CITY OF ALBUQUERQUE

October 27, 2023

RE: John Street Pond Feasibility Design Analysis Report
Engineer's Stamp Date: No Date
Hydrology File: L14D067

Based upon the information provided in your submittal received 10/13/2023, the Analysis Report **is not** approved. The following comments need to be addressed for approval of the above referenced project:

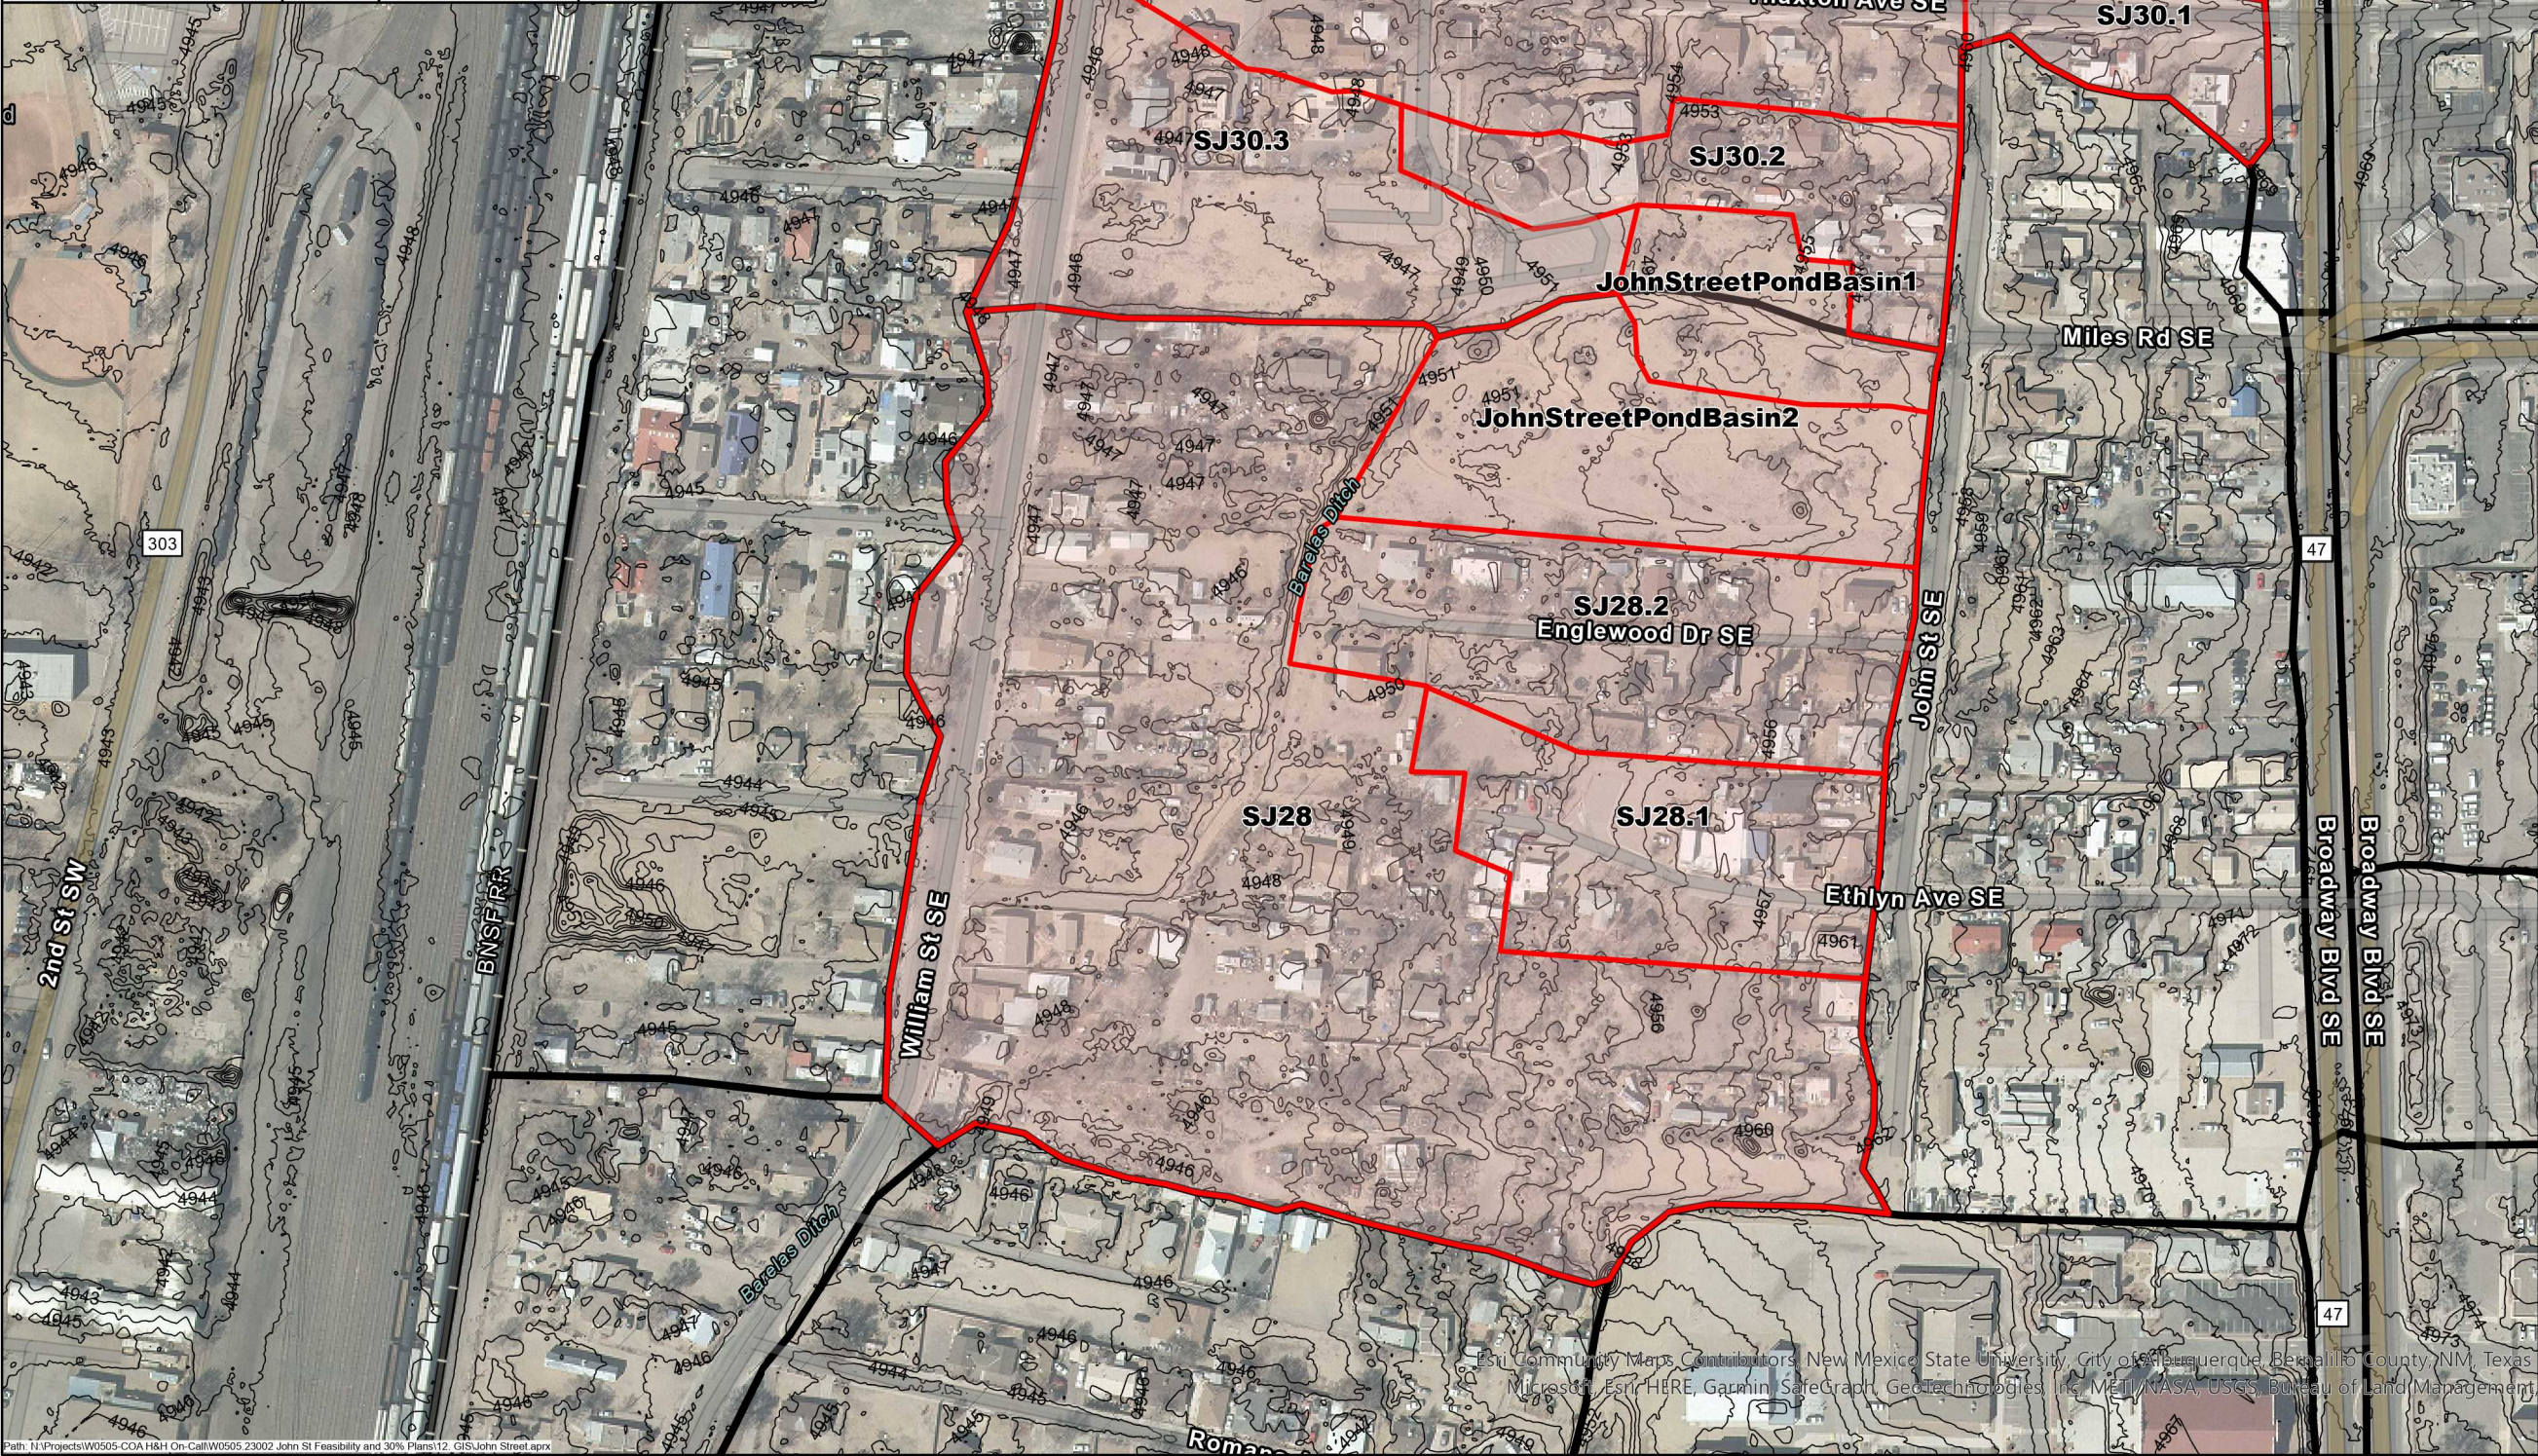
3. In 2.1 Existing Conditions, the section just refers to the updated SBDMP without a map. A map showing the existing subbasins similar to Figure 3 (Proposed Subbasin Map) would be helpful.

4. In 2.2 Proposed Conditions, why are all the Curve Number (CN) the same? Hydrology section has found if you are using a soil map within Albuquerque, then the resulting flows are off. As in the DPM, Hydrology Section recommends using the following CNs depending on the land treatment and using a weighted CN.

- a. The use of just four Curve Number (CN) values, one for each of the land treatments already described in the DPM: A=76, B=80, C=85 and D=98. This way the hydrologic soil groups don't need to be determined to select the CN and the soil maps do not need to be consulted.

- b. For example, John Street Pond Basin 1 has 85% impervious but uses a CN 86. If you use a weighted CN, then you get $0.85*98 + 0.15*85$ which gives a CN 96.

- c. For example, John Street Pond Basin 2 has 20% impervious but uses a CN 86. If you use a weighted CN, then you get $0.20 \cdot 98 + 0.80 \cdot 85$ which gives a CN 87.6.

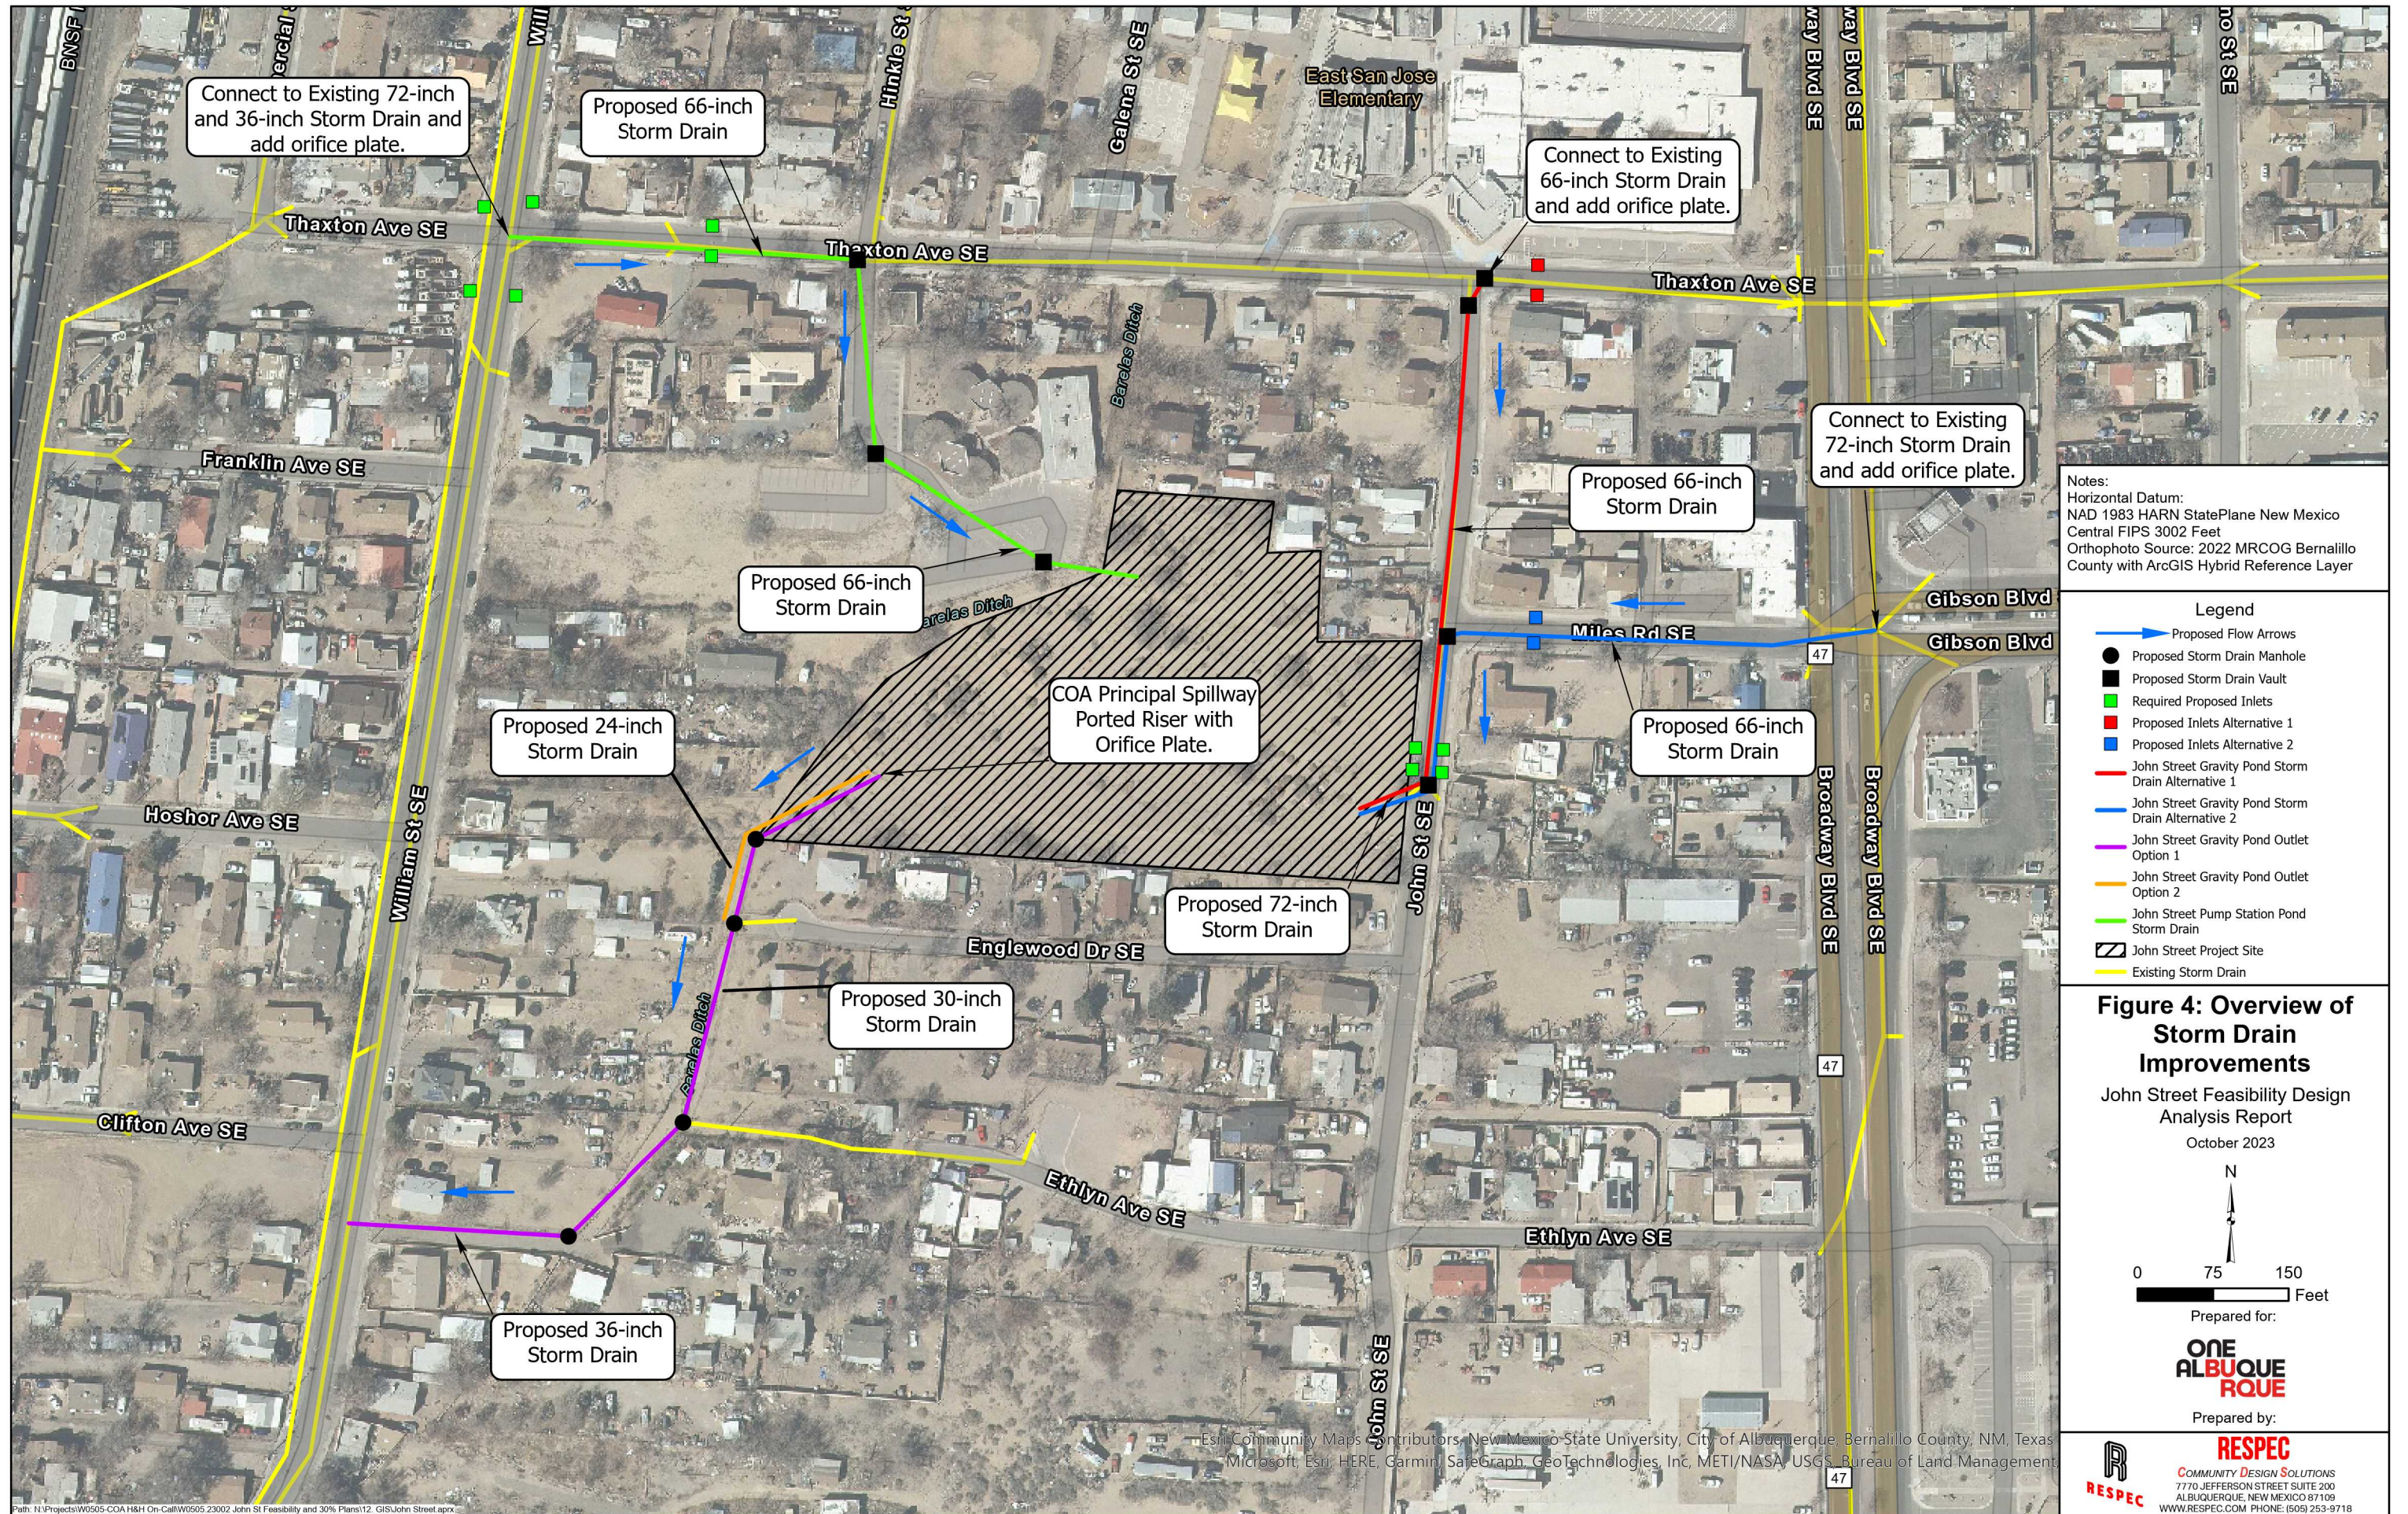
5. Figure 4, Overview of Storm Drain Improvements. It would be very helpful if you include the Q_{100} at the storm pipe for both the existing and the proposed on the map. (See below) This should help explain how the whole proposed system will help with the capacity in the existing storm drain by the proposed detention & pump station.
